BOLTON-BY-BOWLAND, GISBURN FOREST & SAWLEY PARISH COUNCIL

PLANNING APPLICATION NO: 0804/5
RELATING TO RODHILL LODGE, BOLTON-BY-BOWLAND

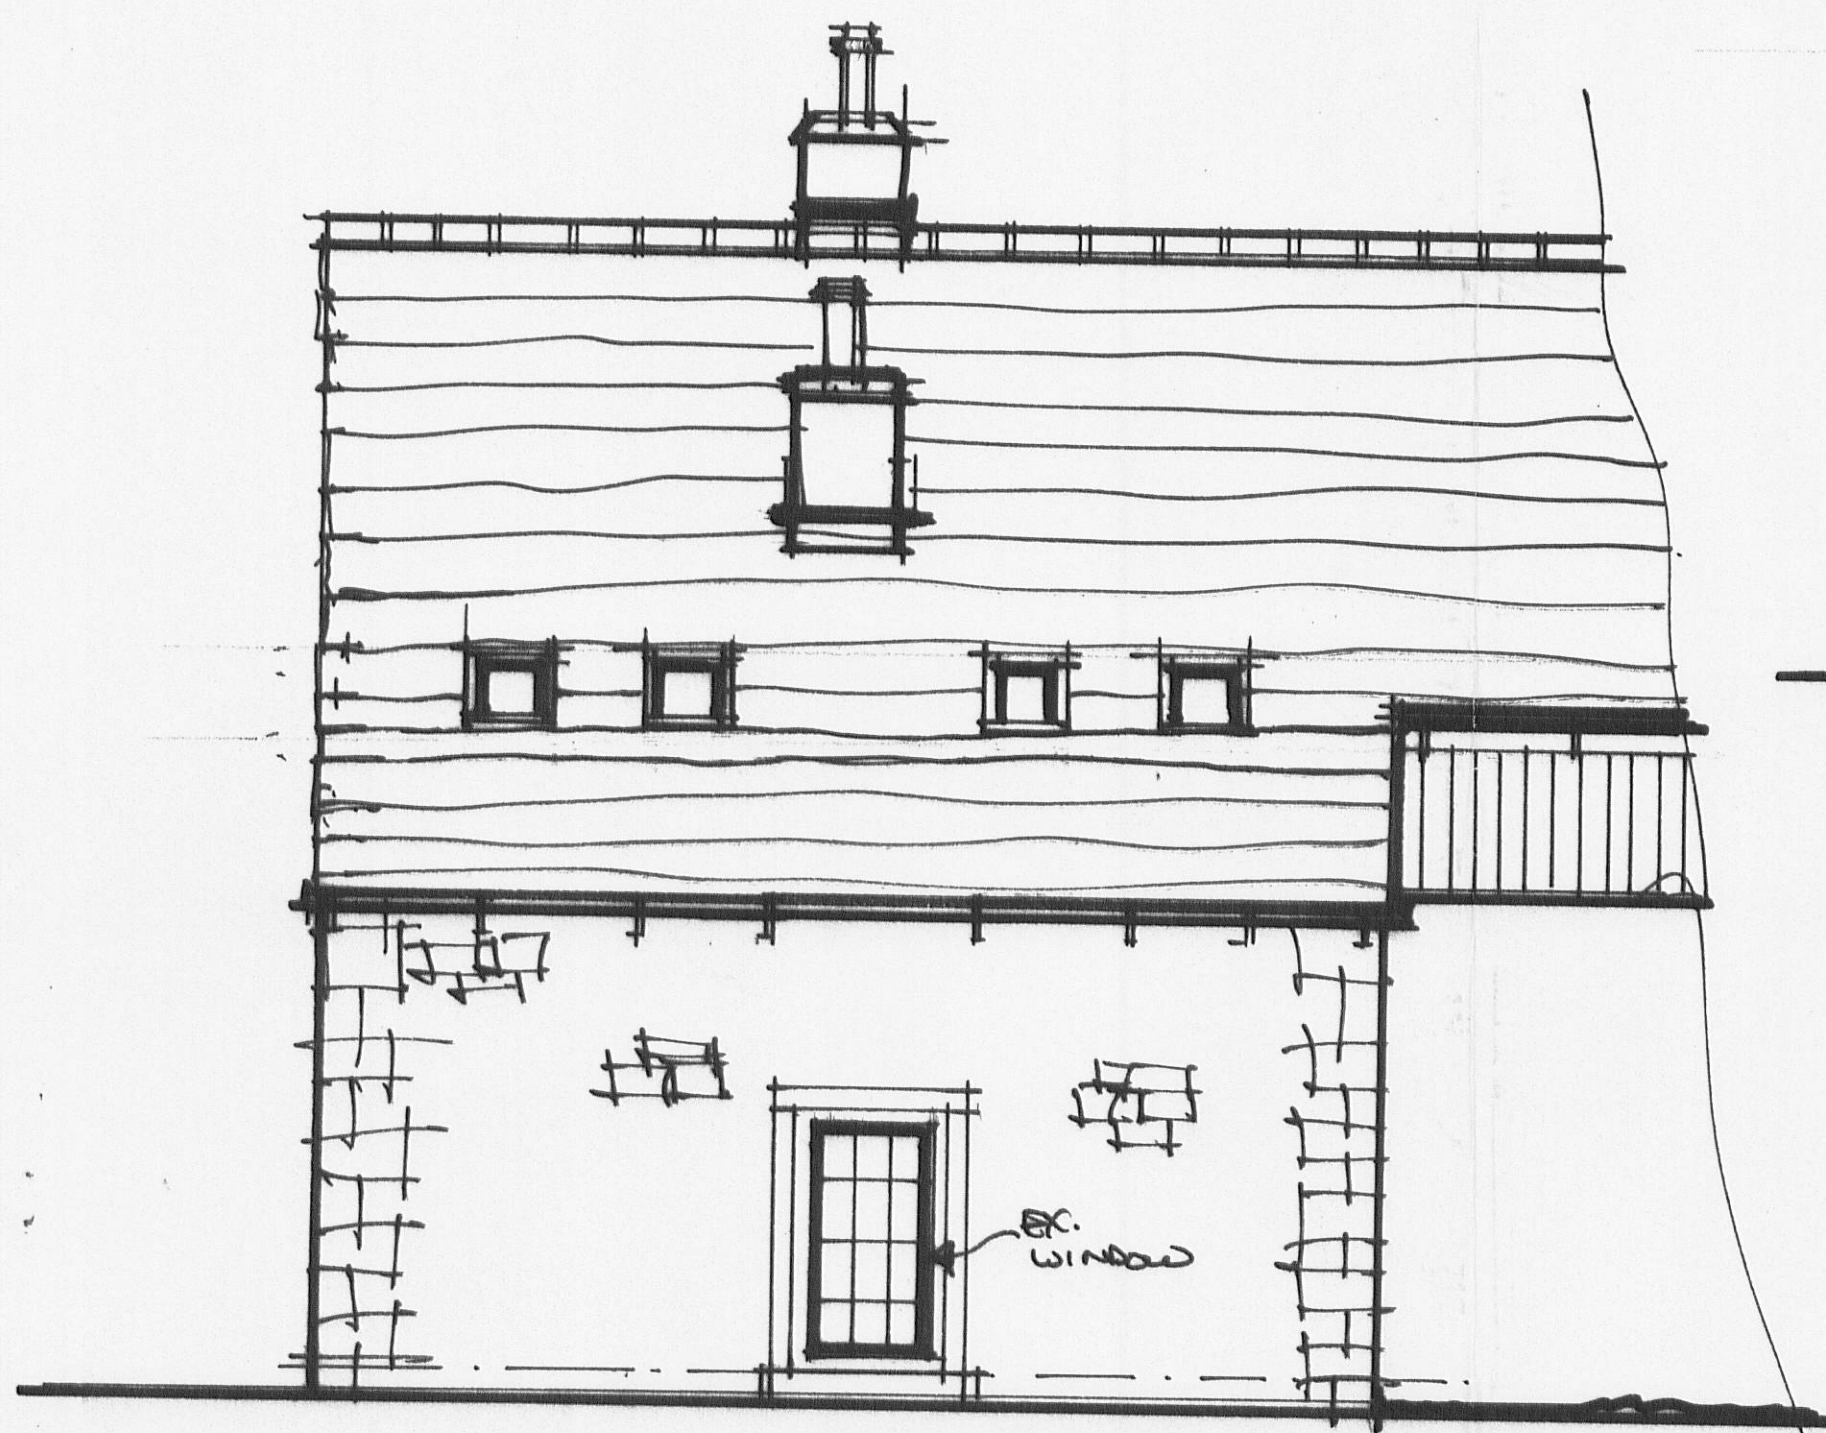
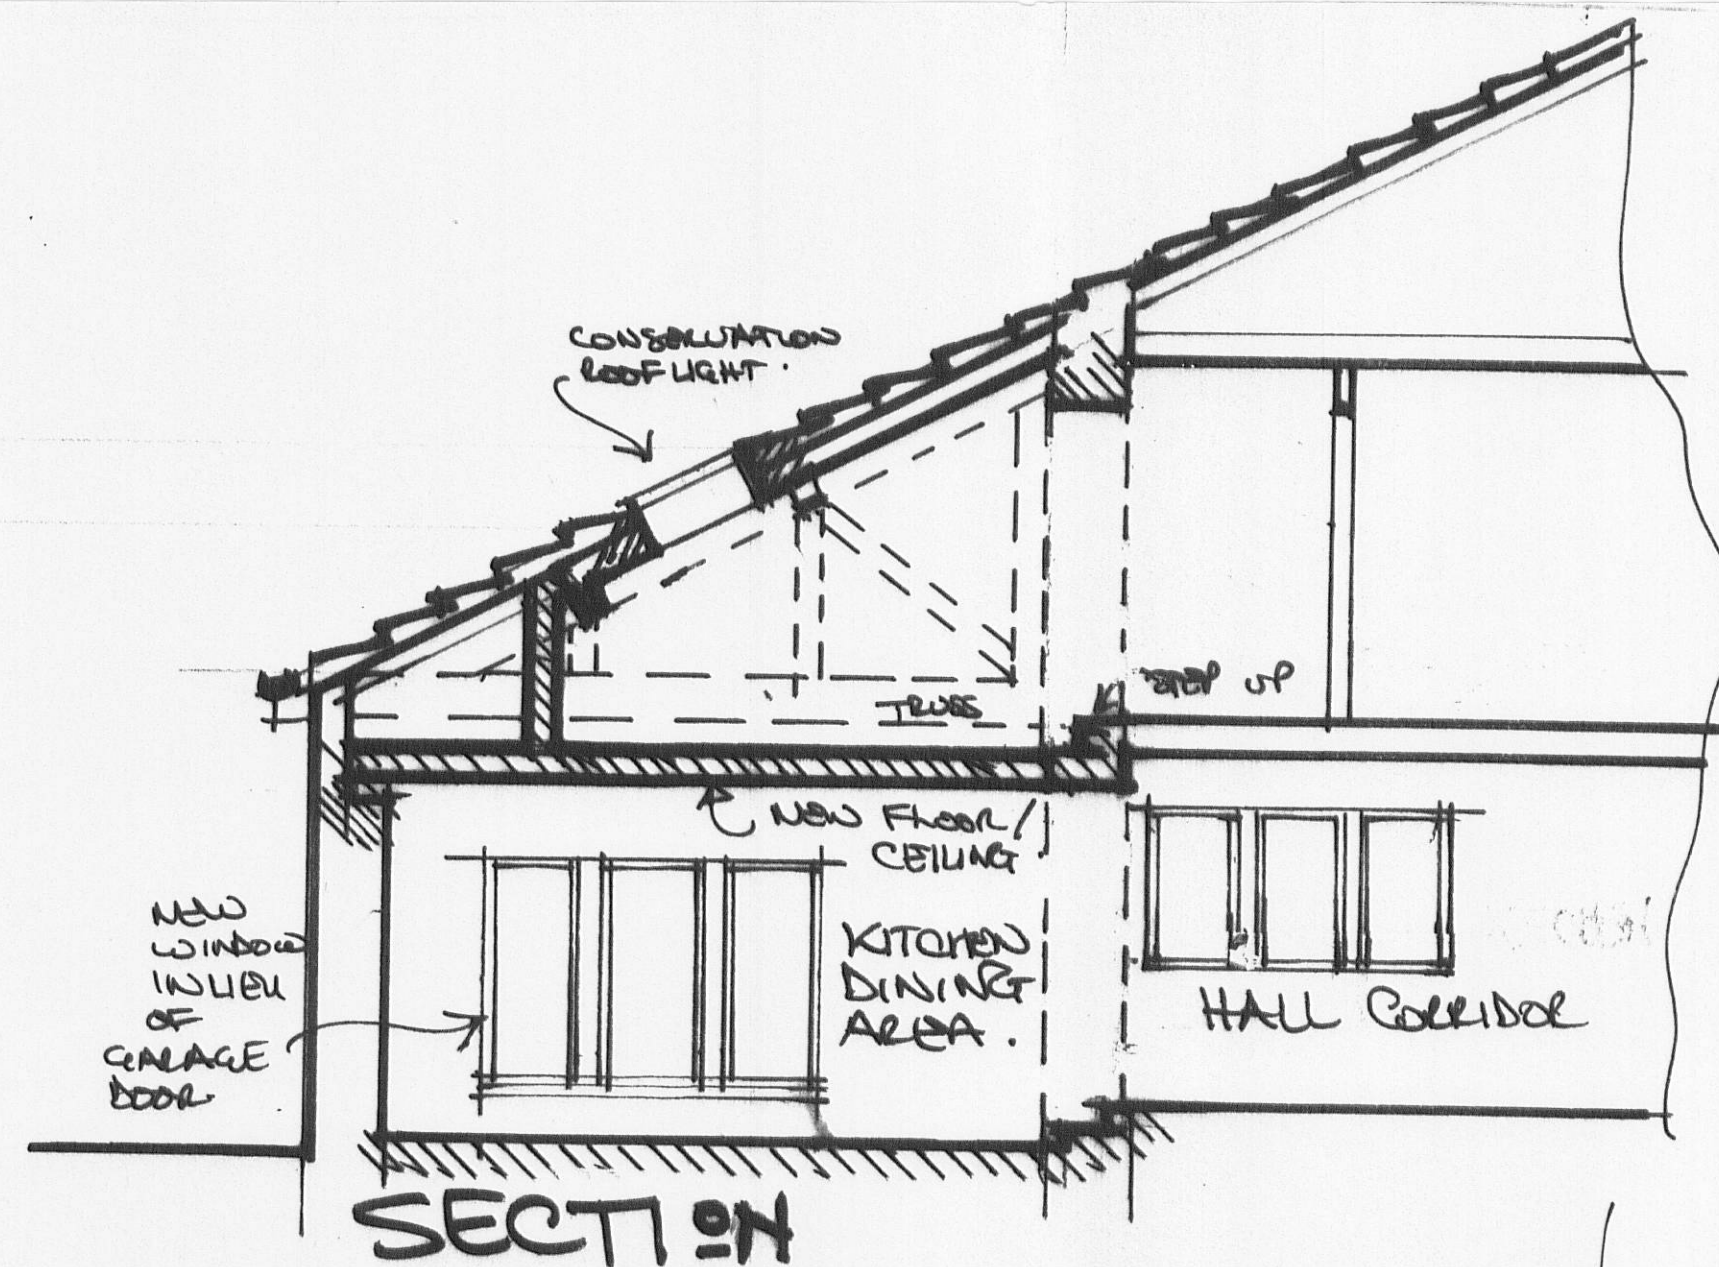
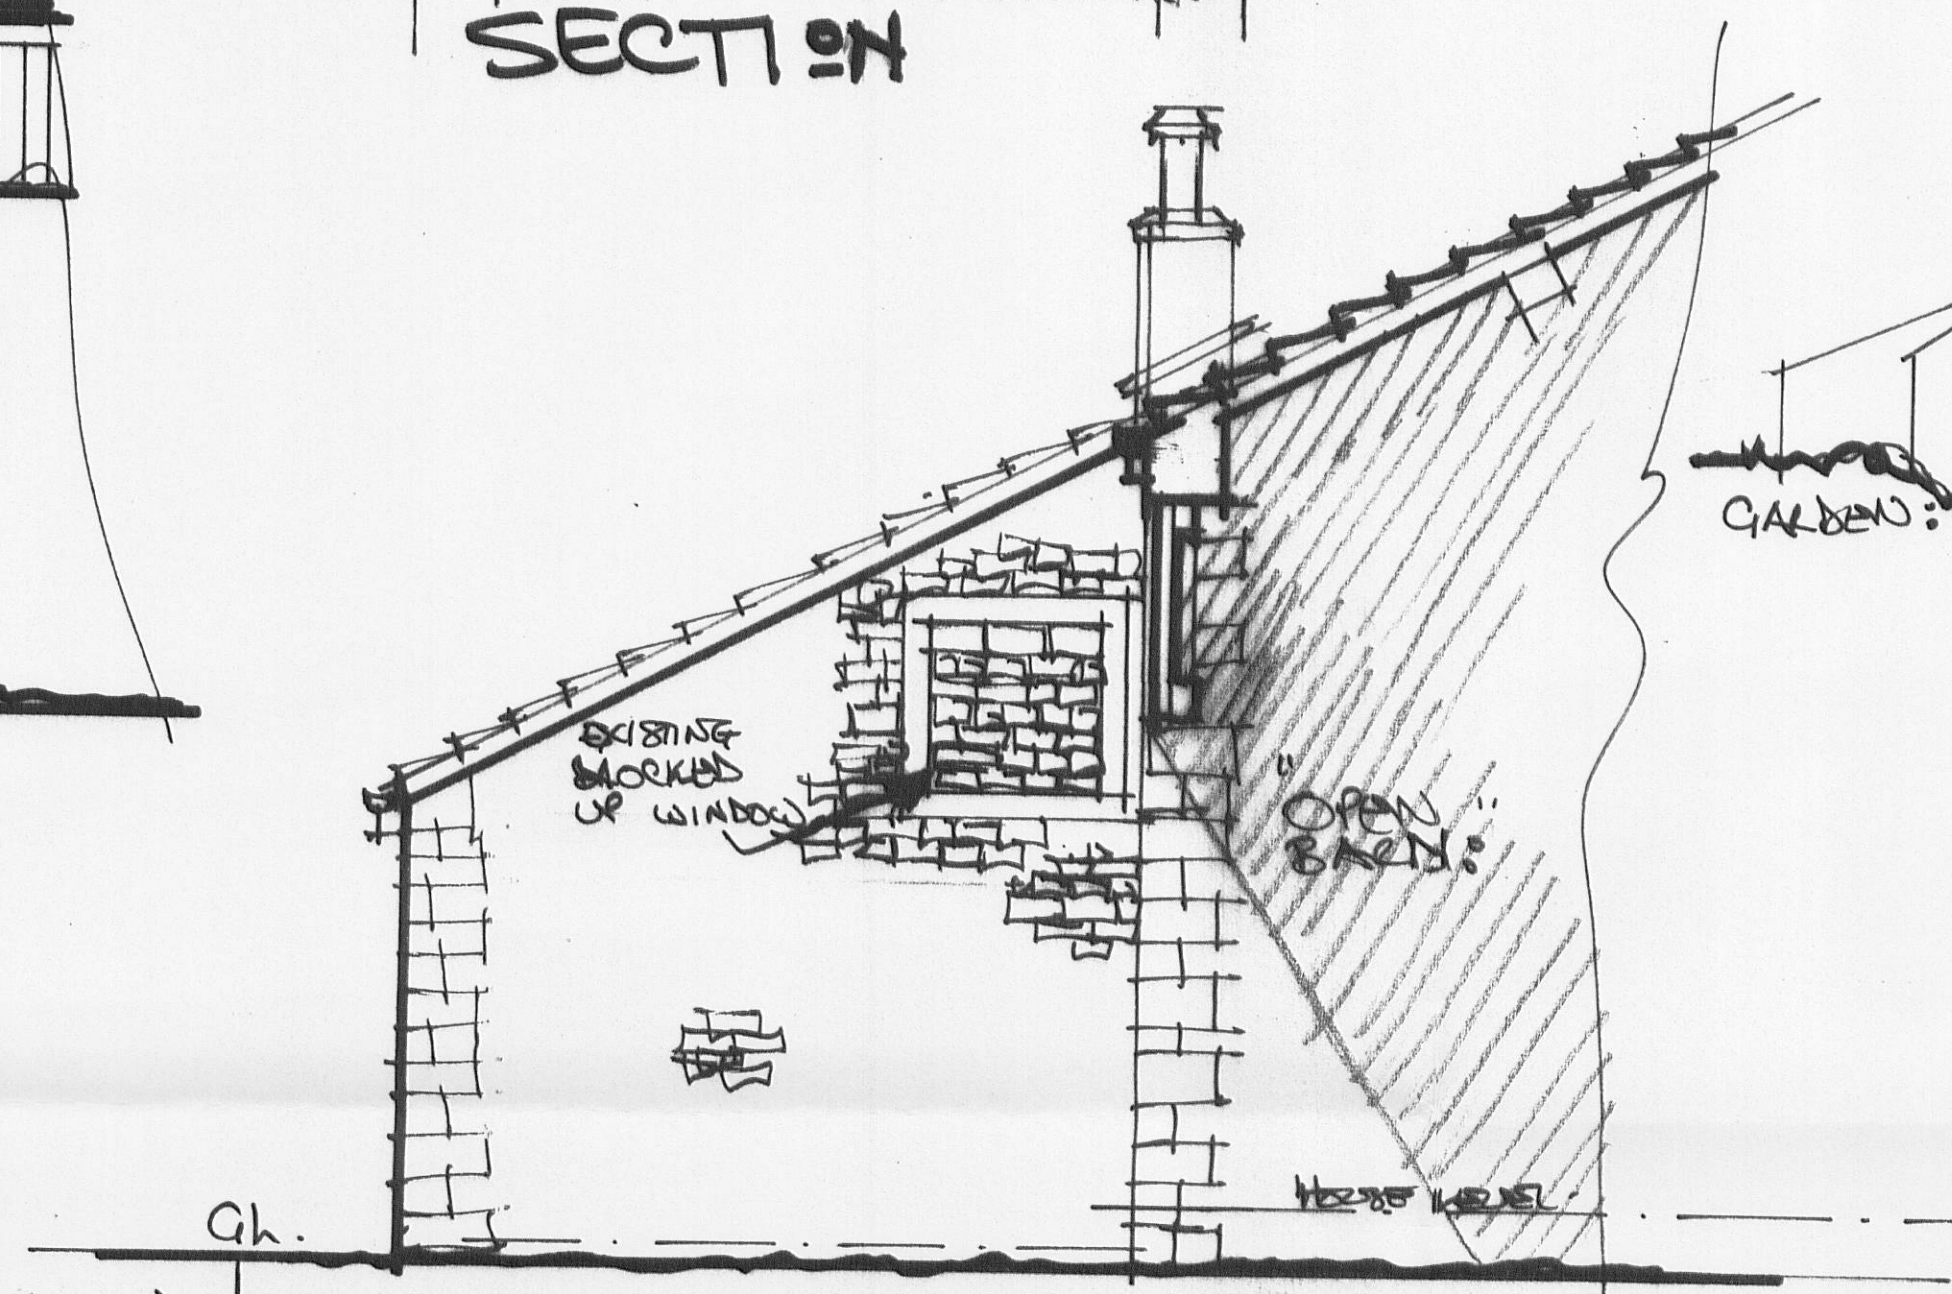
QUERY THE NEED FOR 4 ROOF
LIGHTS ABOVE LOBBY ROOM
